9 April 2021

Re: Statement of environmental effects - Section 4.55 (1A) Modification to SSD 7733 - waste recycling and transfer facility at 46-48 Peachtree Road, Penrith

Benedict proposes a modification to development consent SSD 7733 (Mod 1) to change the material forming the external walls of the main shed. The current approved design includes walls with part masonry and part colorbond construction. The proposed modification includes masonry for all of the external walls.

Figure 3 | Proposed plan for the western elevation showing external walls as full-height masonry wall

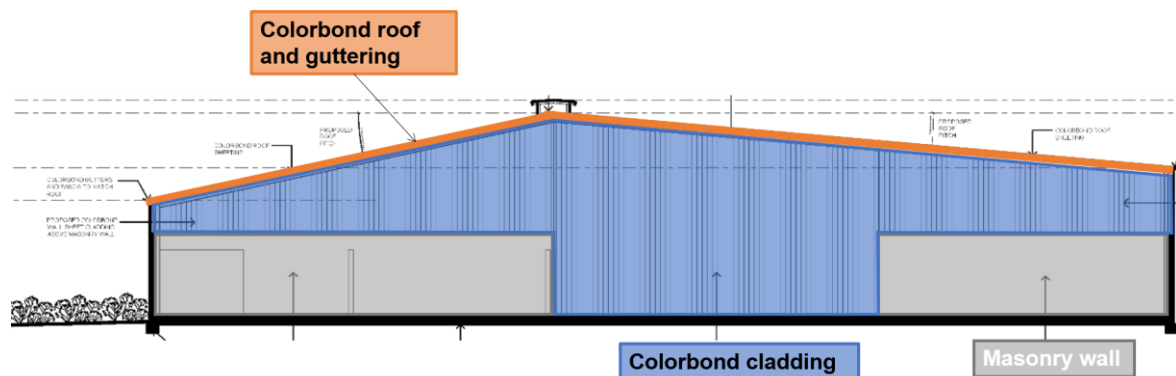
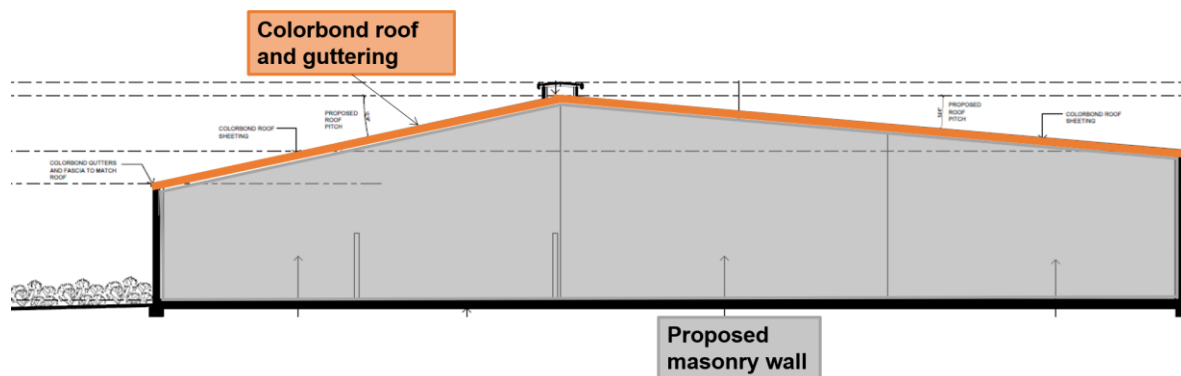
The proposed change of material to masonry is required to increase the fire safety rating of the external walls of the main shed, where it is close to the boundary with adjoining properties.

Since the fire safety strategy was prepared, FRNSW have been insisting on higher fire ratings for the construction of waste facilities. The proposed use of masonry rather than metal on all external boundary walls of the main shed will increase the overall FRL of the building. This will reduce the risk of any fire spreading to any nearby buildings and, in turn, increase the safety of the occupants of these buildings as well as the safety of fire fighters.

02 EAST ELEVATION
SCALE 1:250

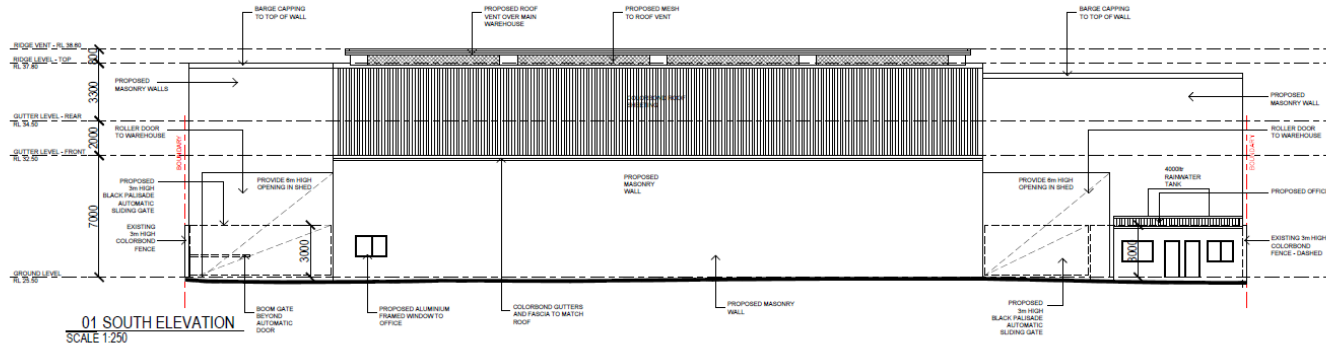
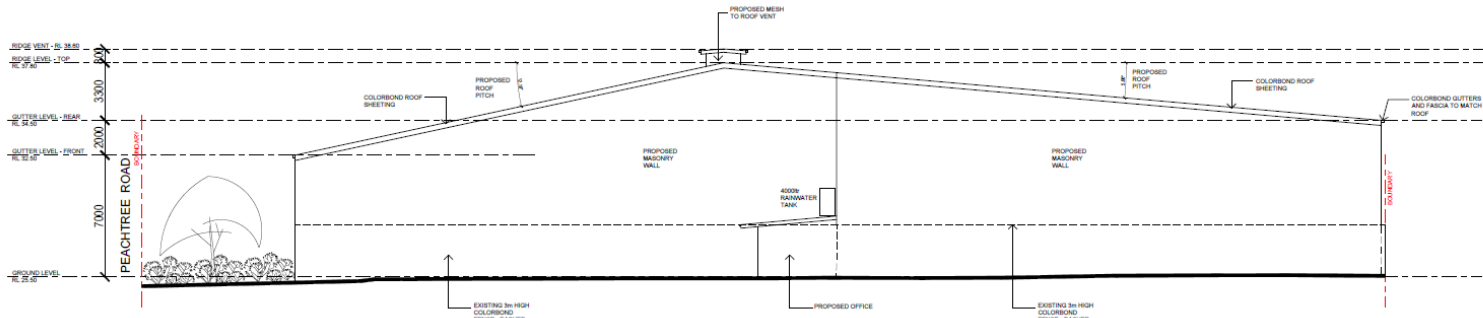
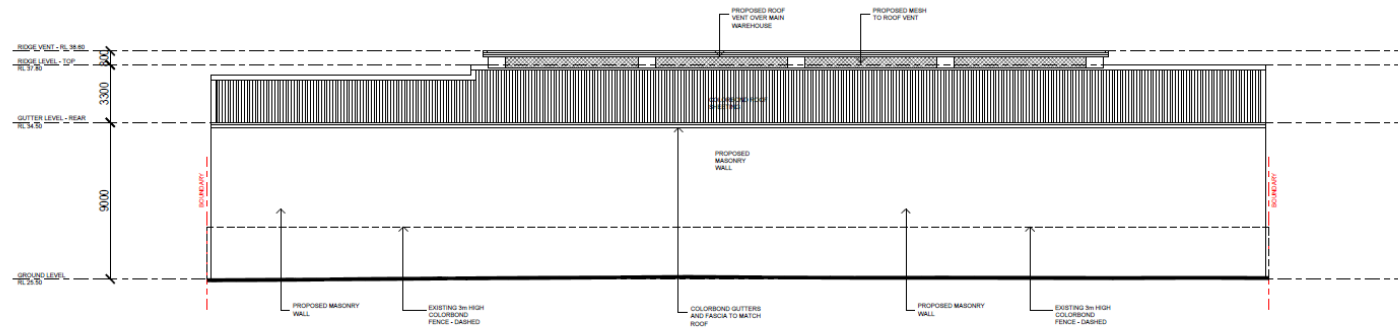
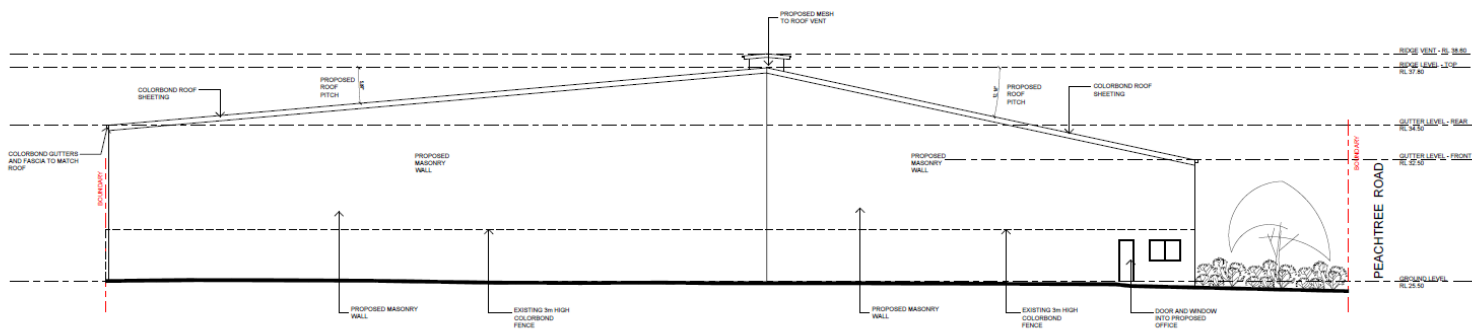
Plan excerpts of the proposed layout and main (east) elevation are provided below in Figure 2.1 and Figure 2.2, respectively. The approved plans are provided in Appendix A and the proposed Plan are provided in Appendix B.
